A428 Black Cat to Caxton Gibbet improvements

TR010044

**9.65 Applicant's comments on other parties'
responses to second round of written questions**

Version	Date	Status of Version
Rev 1	16 November 2021	Deadline 5

Figure 8 – A428 bridge proposal

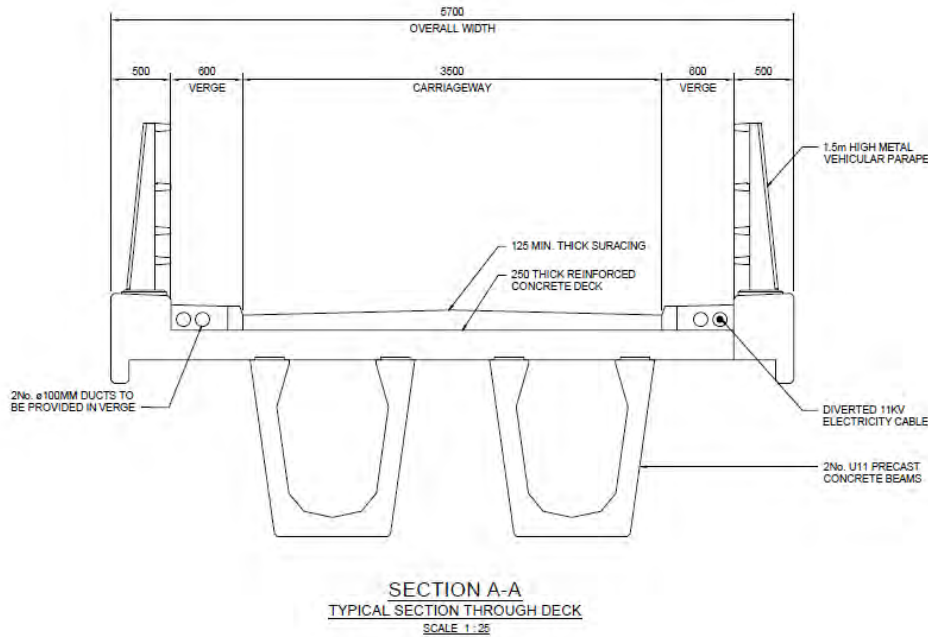
<p>Executors of N A Alington</p>	<p>a) Currently there is an unrestricted access for machinery around the principle arable farming block at Top Farm without having to demount or disassemble equipment. The Applicant is proposing a bridge with 3.5m carriageway and 0.6m borders, a 4.7m total width between parapets, on the basis that the track is about 3.5 m wide. However, the track (and other tracks around the farm) adjoin grass margins or fields and therefore machinery can either run on grass or the track could be widened at modest expense if needed to carry wider equipment. Examples of the current machinery have been provided, together with the widths. The proposed bridge in some cases is of insufficient width for the machinery, or in others is theoretically wide enough (eg Quadtrack at 4.2 m, combine without header) but the tolerance or clearance is too small to be safe and damage to the protective fencing and machinery is likely. Farm machinery has increased in size as farm sizes increase and bridges of sufficient width in the late 20th century are now too small to be of practical use.</p> <p>The best example of obsolescence is the underpass under the East Coast Mainline at the Little Barford Estate. Other examples in the locality are:</p> <p>M11 Cambridge - Cantelupe Farm Trumpington</p> <p>The construction of the M11 finished in 1980. Cantelupe Farm to the south-west of Cambridge was severed by this road scheme. To connect the blocks of farmland a bridge of 4.7m total width between parapets was provided.</p> <p>Cantelupe Farm is operated by a large farming business with modern equipment of similar or larger size than used at Top Farm. The farm was a ring-fenced unit without restriction on farm machinery (then smaller than now) but the M11 severed off proportions of the farm and two bridges were provided. The bridges are of insufficient size (and bearing) for the farm and are only used by smaller farm equipment. Instead large cultivation machinery needs to be taken onto the public road network. For the smaller block of land cropping has been changed, for example use</p>

No.	Question/Applicant's Comments
	<p>We consider that HE accepted that the 4.7m wide bridge would restrict use and therefore is investigating the provision of a bridge sufficient with to accommodate machinery up to 6m wide safely. For the avoidance of doubt this bridge must have a weight bearing capacity of not less than the maximum permitted weight for road vehicles (currently 44 tonnes). This would be an acceptable compromise for the Executors.</p>
<p>Applicant Comment:</p>	<p>The Applicant notes the comments made and would refer to its response to Q2.5.3.3 and included in 9.47 Applicant Response to the Examining Authority's Second Round of Written Questions [REP4-037].</p> <p>In particular, the Applicant wishes to reiterate the point that further discussions have been held with the Executors' agent on 21 October 2021 and the design of the bridge and current operational farming requirements were discussed. The Applicant is currently reviewing the design of the bridge as discussed at that meeting on 21 October 2021 and the Applicant is considering whether an alternative width is deliverable as a compromise between the two parties. The Executors' Agent is also considering whether an alternative width is acceptable to their Client.</p>
